From: Sue Howell <Sue.Howell@arun.gov.uk>
Sent: 06 October 2021 12:39
To: Planning.Responses <Planning.Responses@arun.gov.uk>
Cc: Anita Gardner <Anita.Gardner@arun.gov.uk>
Subject: Planning Consultation on: FG/145/21/DOC

Application ref: FG/145/21/DOC

Description: Approval of details reserved by condition imposed under ref FG/115/17/PL relating to Condition Nos 6 - parking spaces, turning facilities & garages, 7 - surface water drainage, 8 - landscaping, 10 - cycle parking, 11 - materials & finishes and 12 - screen walls and/or fences.

Location: Paddock House 44 Ferringham Lane Ferring BN12 5LU

Project Title:
Pebble Lane, Ferringham Lane, Ferring, W. Sussex
Globe Estates Southern Ltd.
Drawing Title:
Detailed Planting Drawing
Sheet 01 of 02

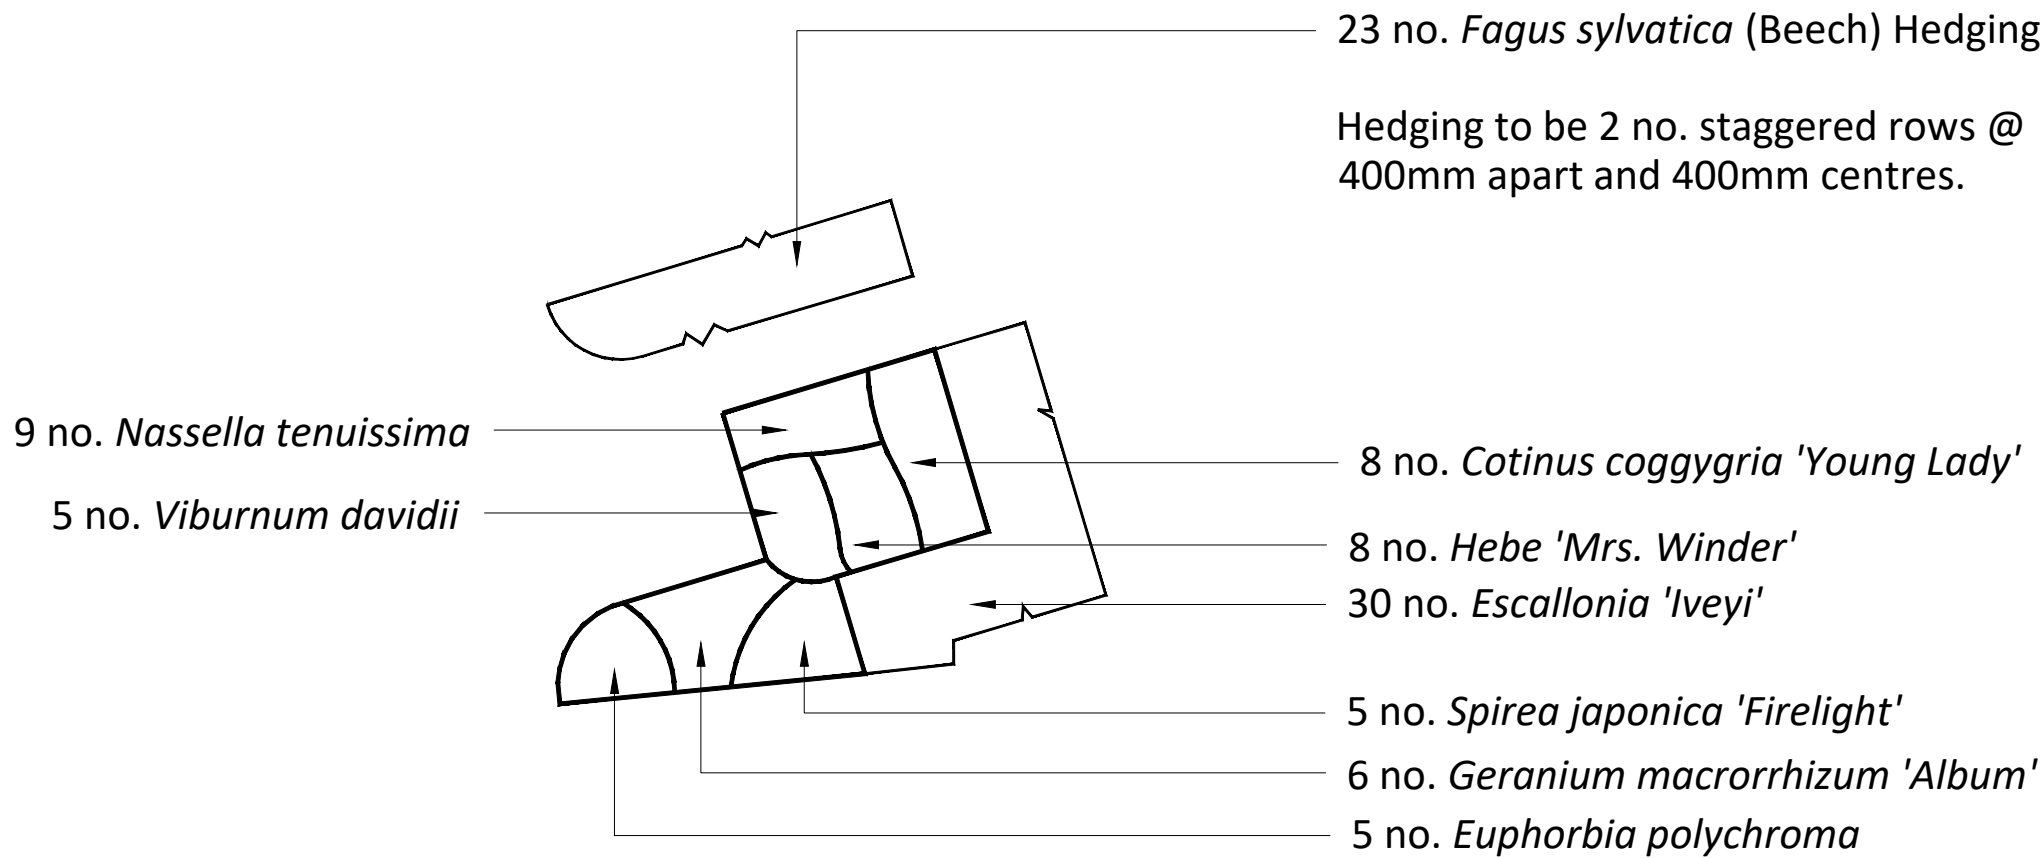
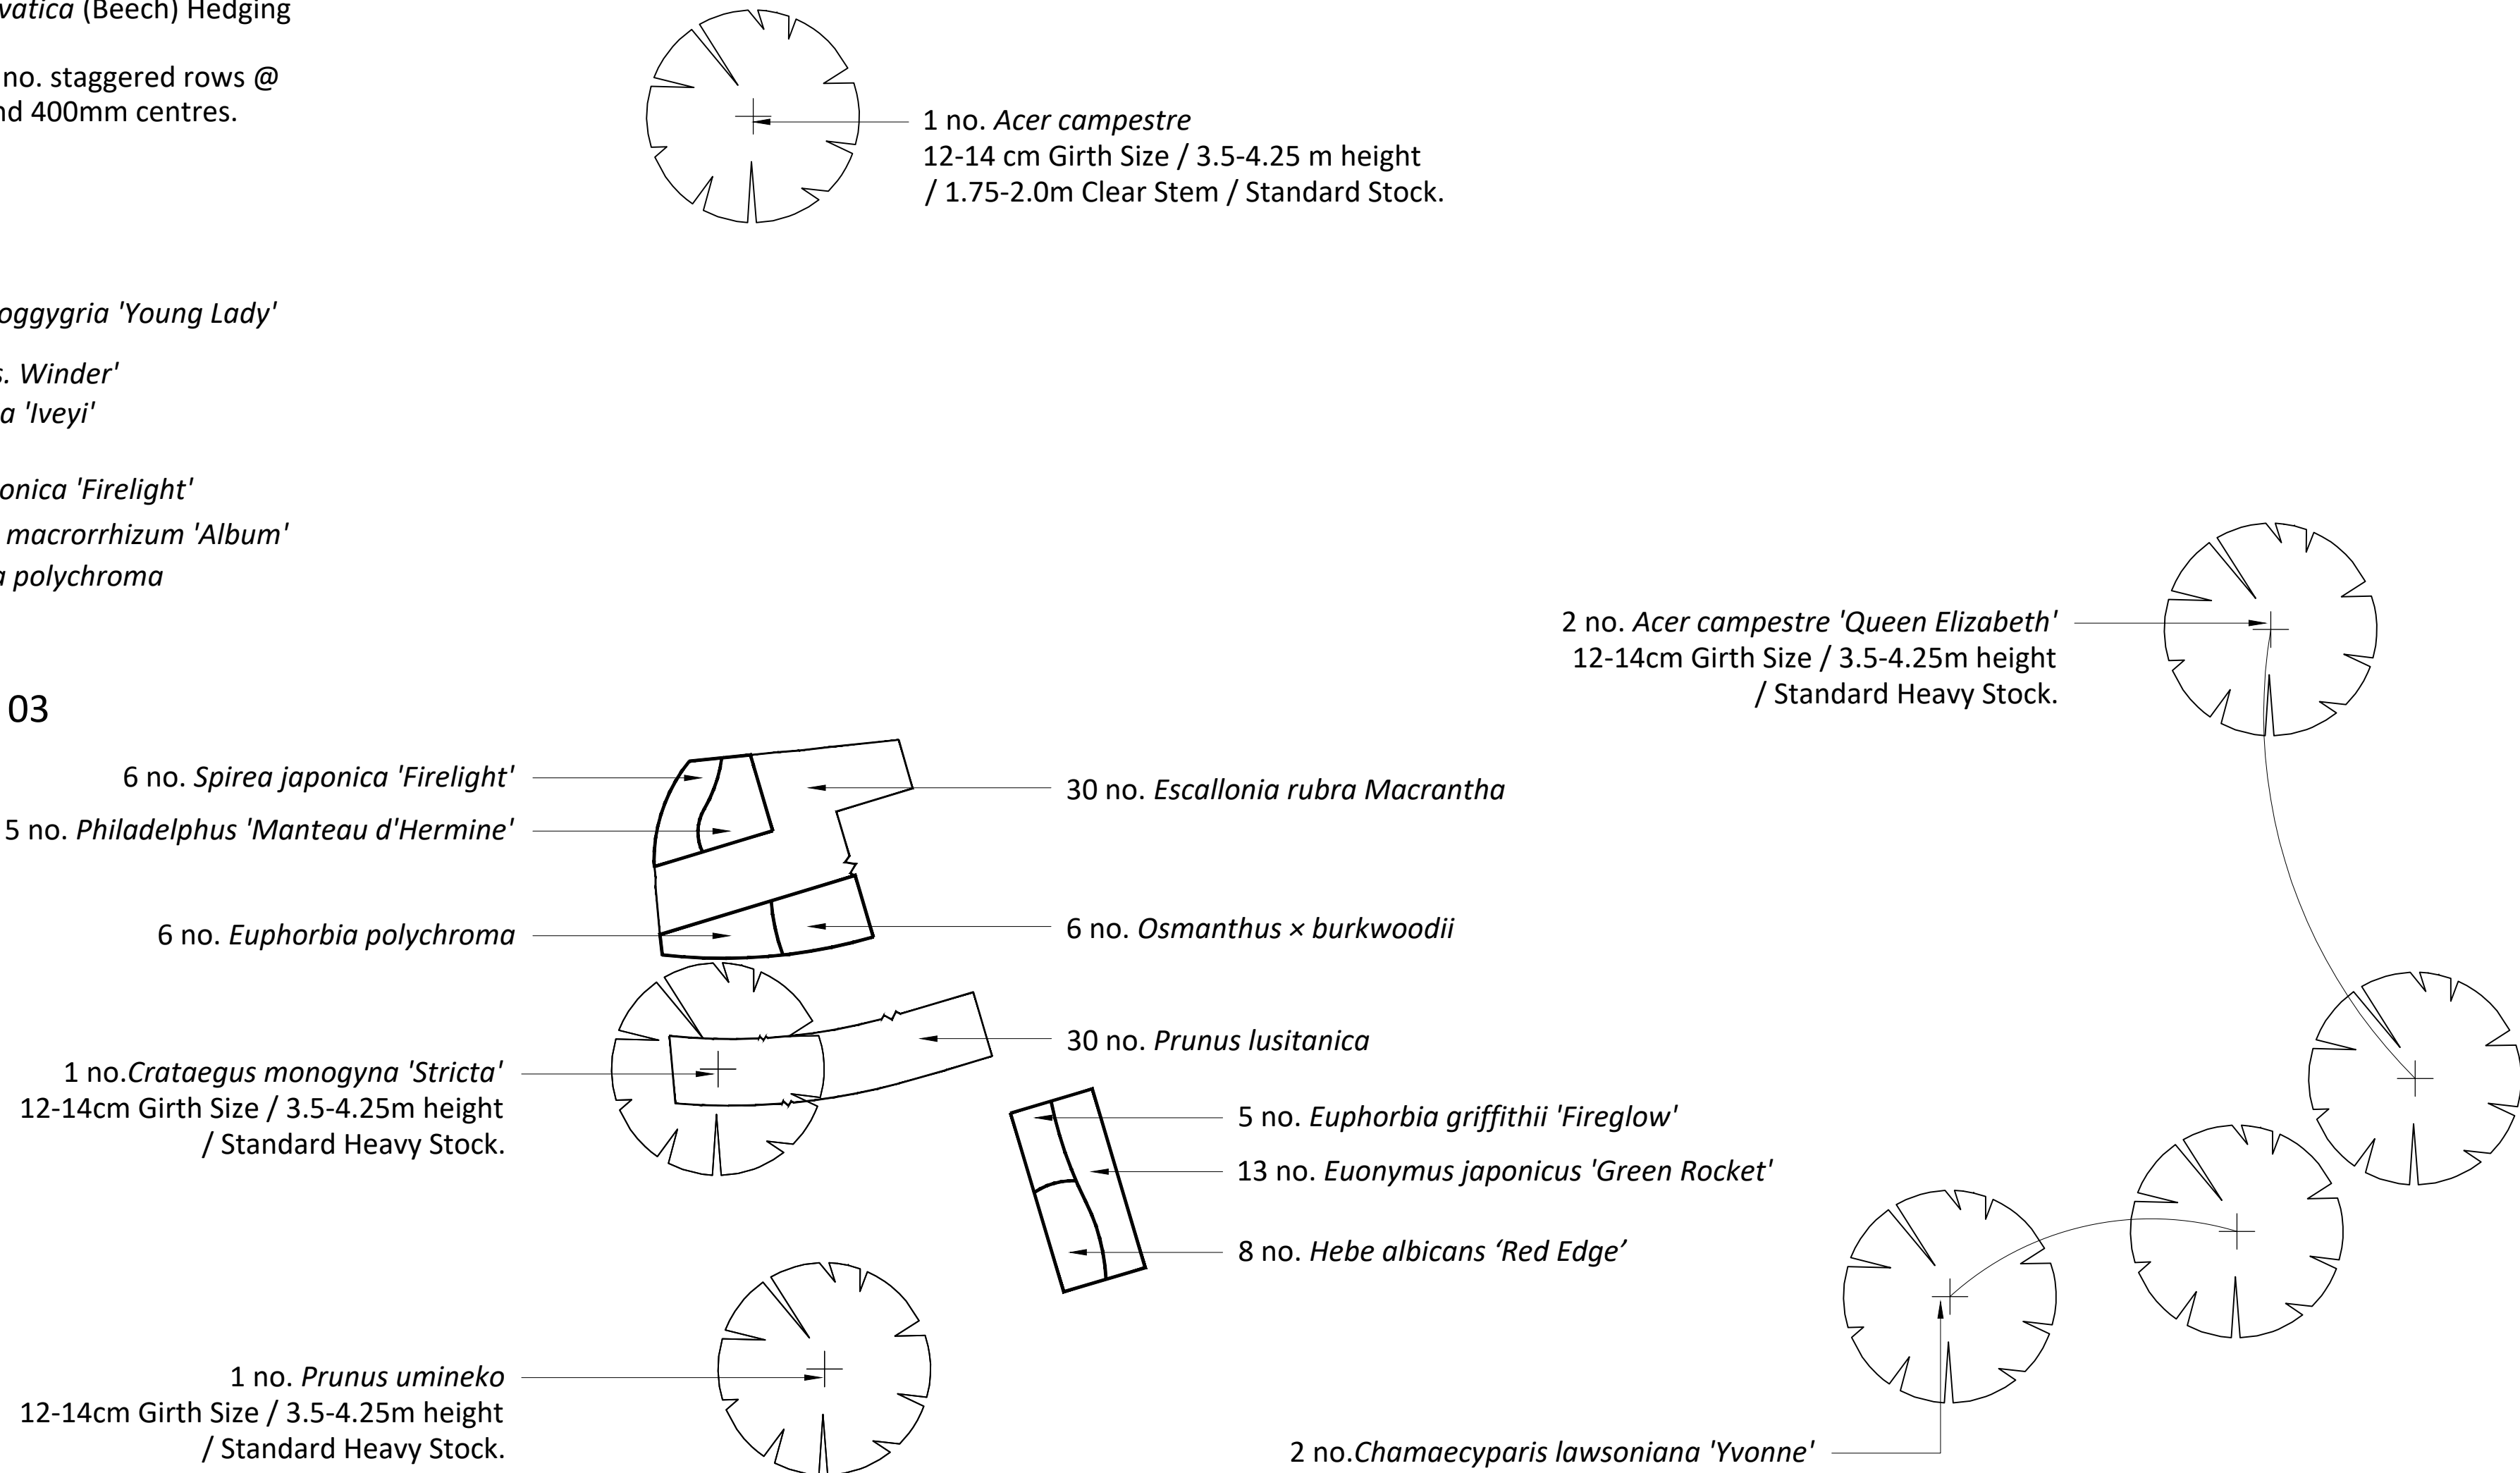
Details have been provided in plan form in the Detailed Planting Drawing sheets 1 & 2 of 2 No RCo391/02 & 03 Rev 00 which has detailed an imaginative and well-chosen scheme which would be suitable for setting with a comprehensive range of evergreen and deciduous, native and ornamental species. The detail has shown existing to be retained hedging, which also provides the scheme with context.

The landscape scheme proposed is suitable for purpose and location and therefore recommend approval for discharge of Condition 8 Landscape details under this application FG/145/21/DOC imposed under FG/115/17/PL.
